27 May 2021

21/00517/F: Wroxton Motocross Track

Viewpoint Location 5: Bell Road

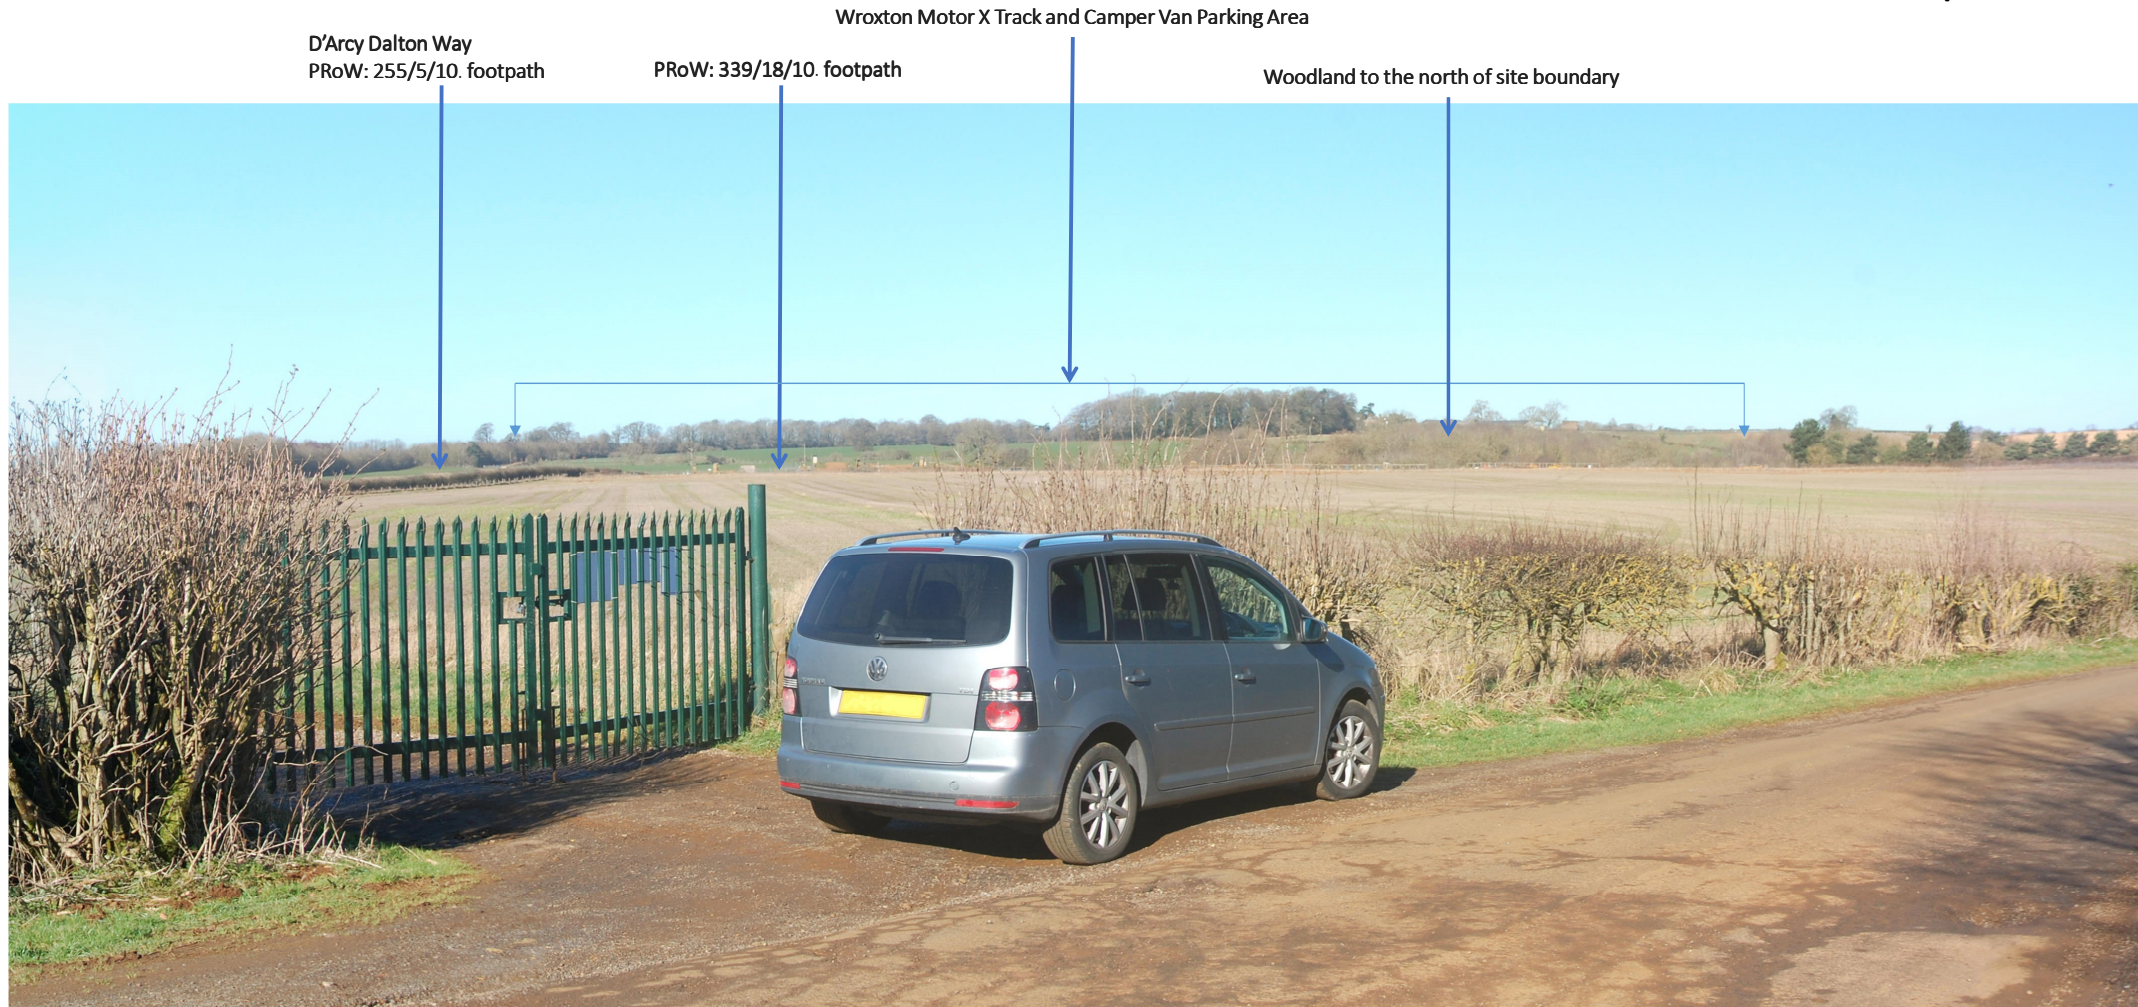
Typed on the map contained within the LVIA (revised) document are a number of comments, amongst them are;

"Bell Lane

This section of Bell Lane has mature roadside hedging and trees which provide visual screening views to the east. However, there is a single location at the bridge with views toward the site."

"Bell Lane"? From the map used in this document, this agent actually means the unnamed single carriageway on which Wroxton Heath is situated. "There is a single location at the bridge with views towards the site". This is just one example of this agent deliberately trying to ignore the fact

that people actually live here, in houses, or, as Mr Steele seems to like describing our residential properties, "intervening" "local buildings", in this case, all of twenty metres or so from his "single location". In fact, there are numerous locations with "views towards the site", from inside my house and from my back garden being just two of them.

"Motor X Track – The track is an established feature in the local landscape and the majority of the track is located in the 'lower' parts of the field and from this location can not be seen. However, there are small sections of the track [can be seen along the eastern and southern edge."

On this occasion, partly correct, yes: my "intervening" "local building" / house, is to the south east of the site and I have a very good view of the 'site' from my property, so, in fact, again correct, the site **can** be seen. I have also seen this site getting bigger and bigger, the jumps being engineered higher and higher, with the addition of more and more permanent features. I have also seen the applicant, Mrs Kerwood (who's favourite trick is to feign ignorance of what is happening on her land) along with others, inspecting her motocross circuit. However, perhaps the word "established" should be replaced with the words "unlawfully built and continuously enlarging, especially since 2017".
